Freedom Forever
Planset Revision Letter

12/30/2023
REV #1

Attn. Harnett County (NC):

JESUS GONZALEZ
11 VISTAS COURT, LILLINGTON, NC 27546

THREE LINE DIAGRAM			
JOB NO: 354438	DATE: 8/8/2023	DESIGNED BY: V.	SHEET: PV-4

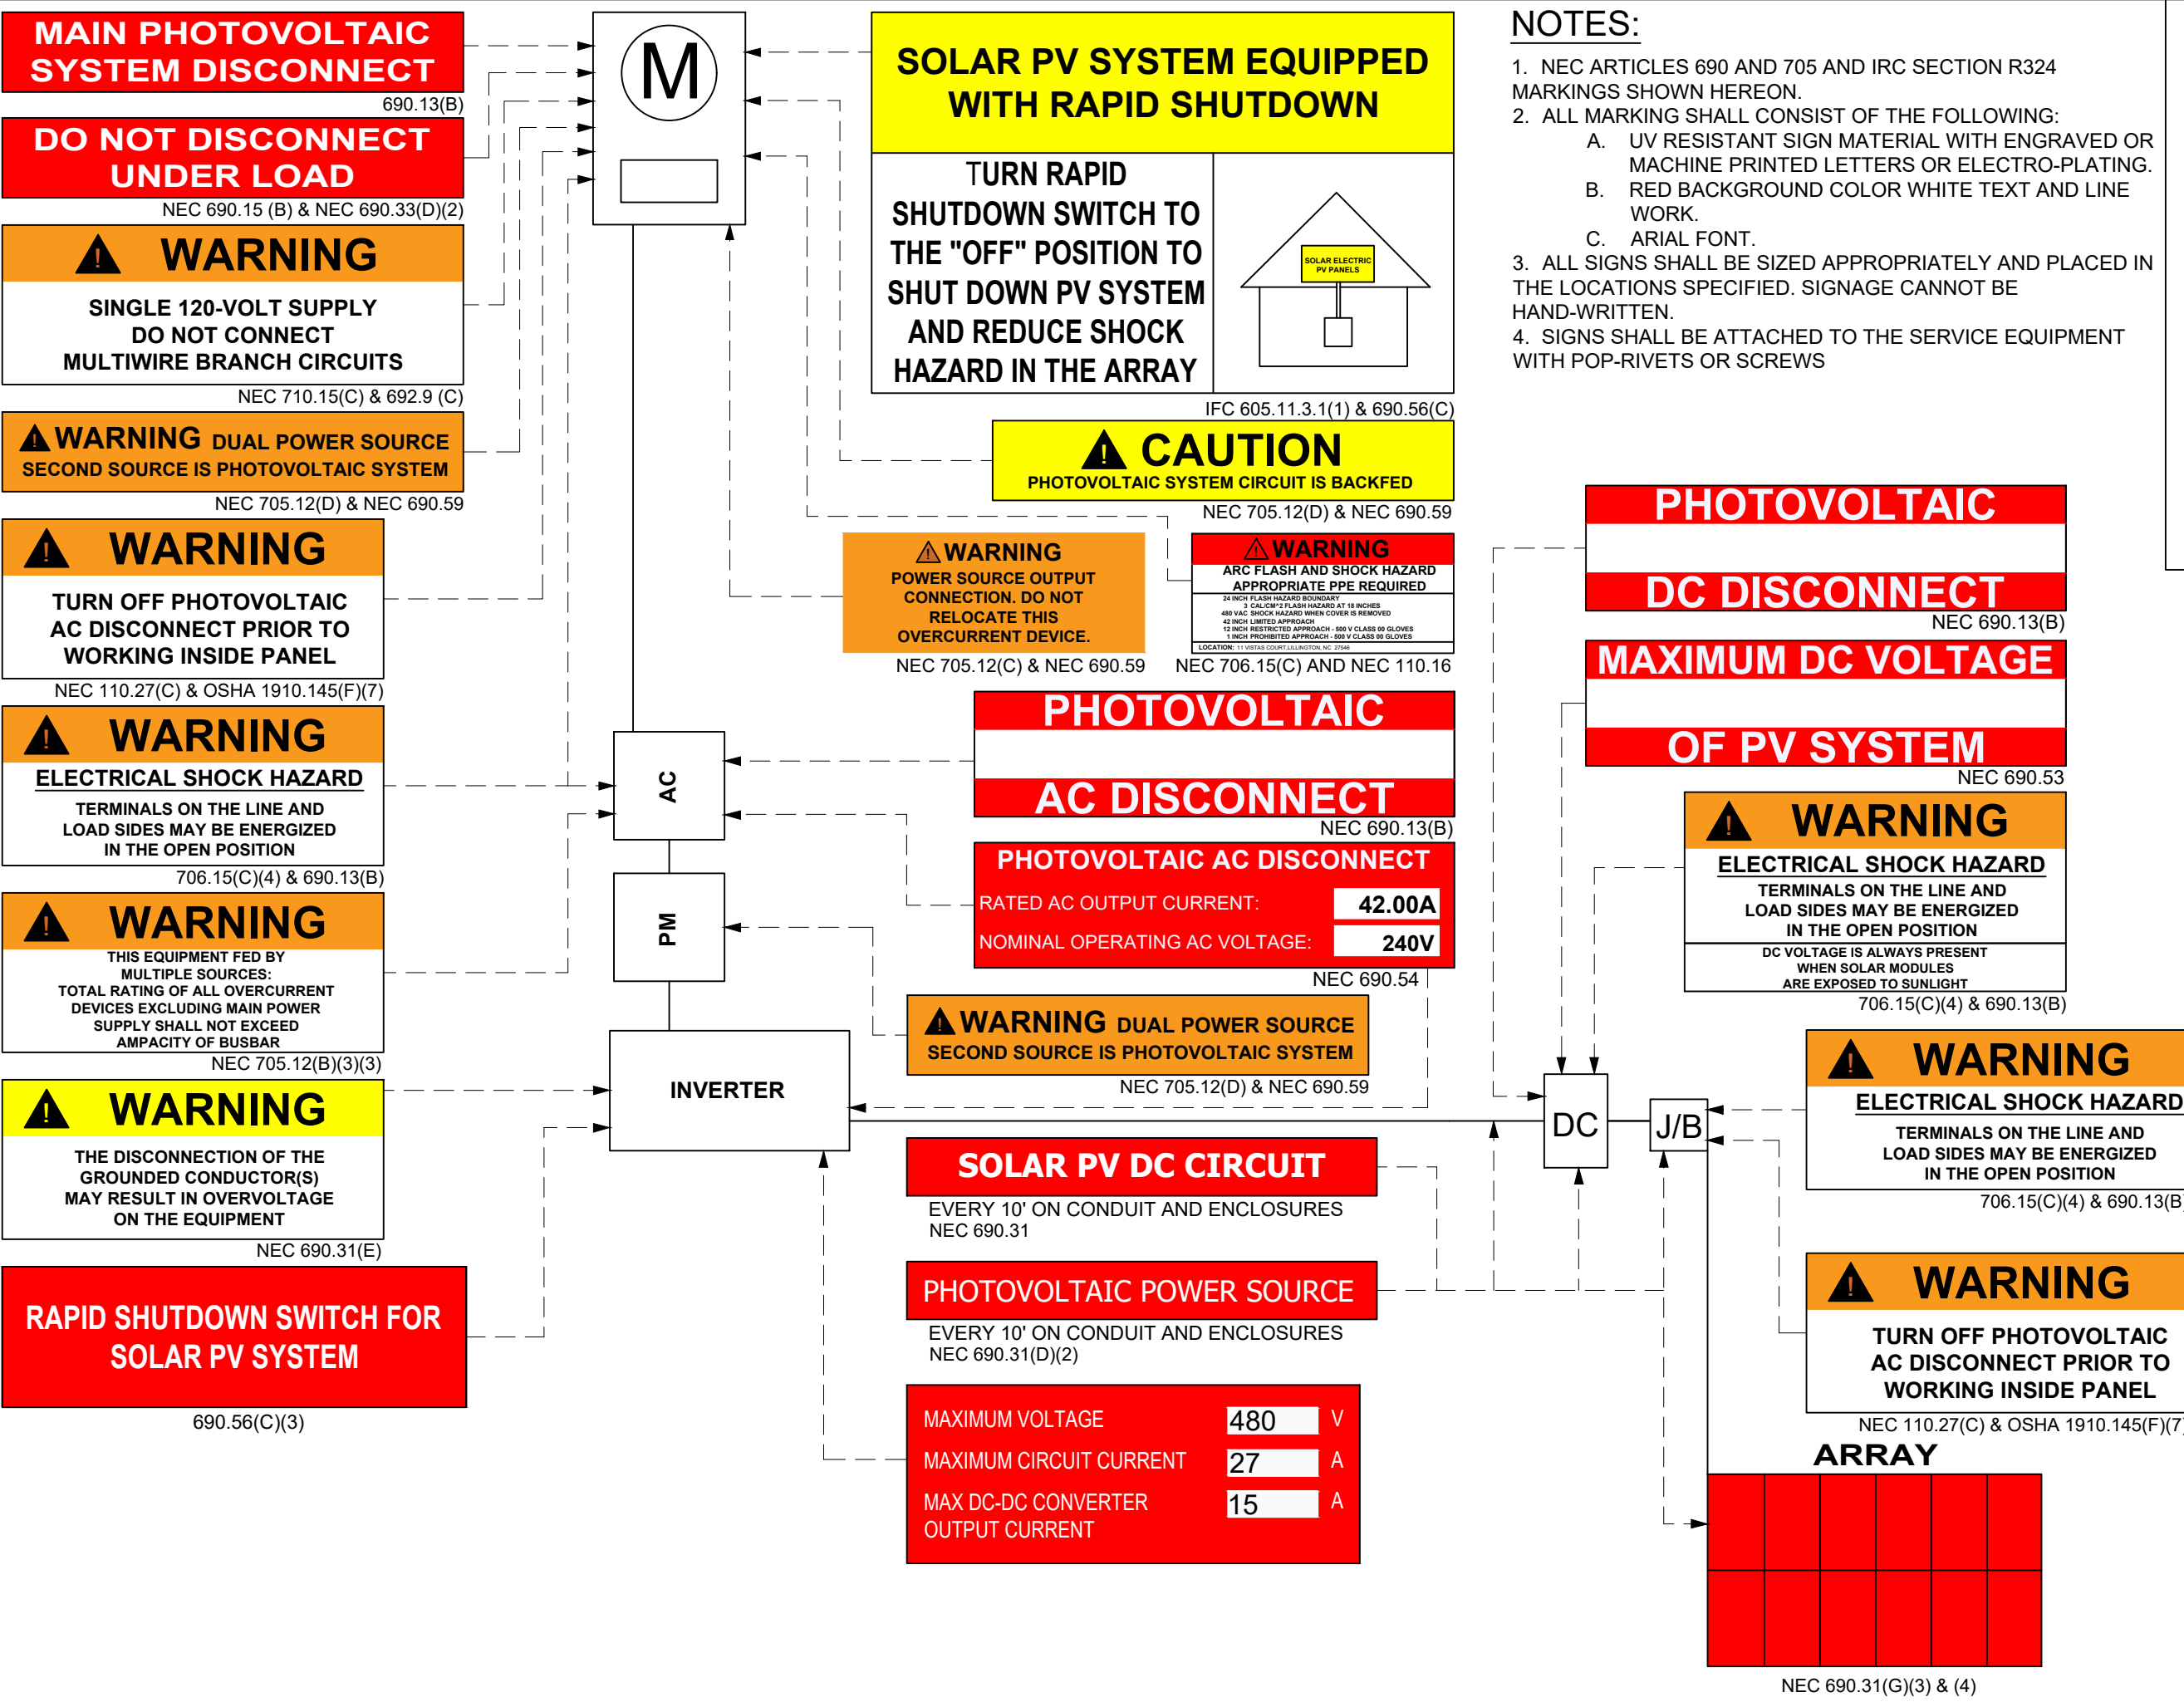
1. MSP corrected to 200A (hot bus) - page PV-4
